From: Michael Eastham
Sent: 13 June 2018 11:48
To: Planning.Responses
Subject: FW: The Lillies, Yapton Road, Barnham

From: Laura Gibbons
Sent: 30 May 2018 09:45
To: Michael Eastham
Cc: Paul Cann
Subject: RE: The Lillies, Yapton Road, Barnham

Section A-A 1:200

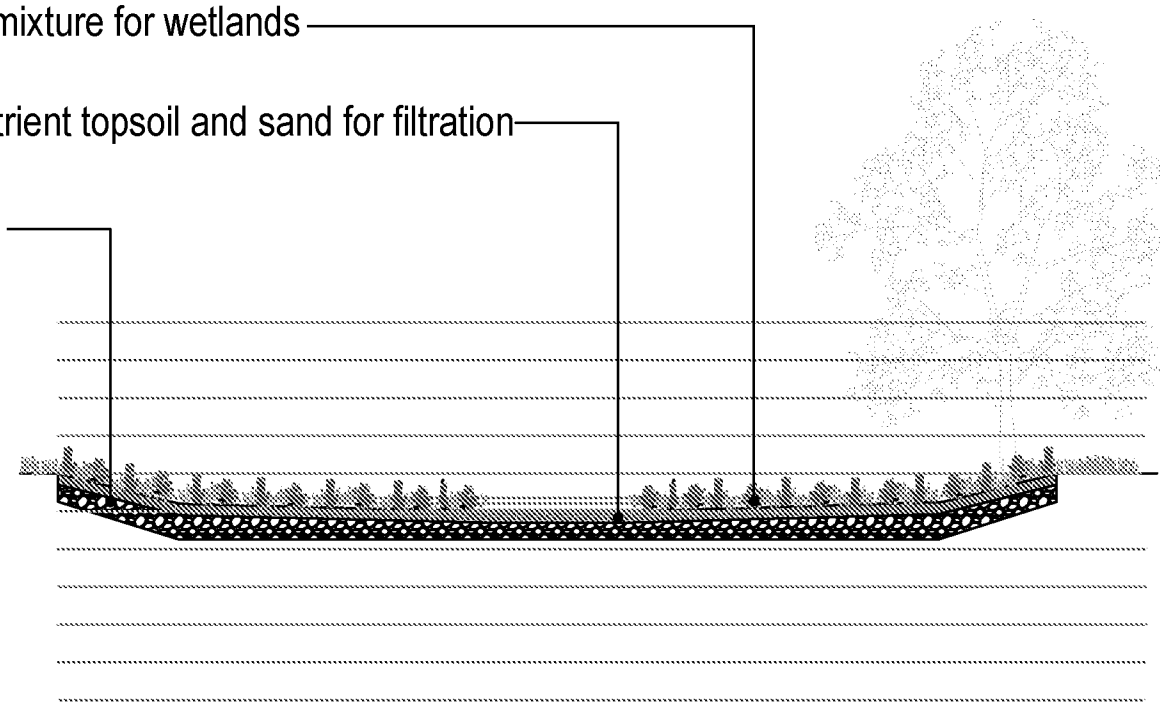
Michael,
I have had a look at the new layout sketch. My previous comments still apply.
It is unclear from the new layout if the pond is now providing online or offline storage.
Thanks,
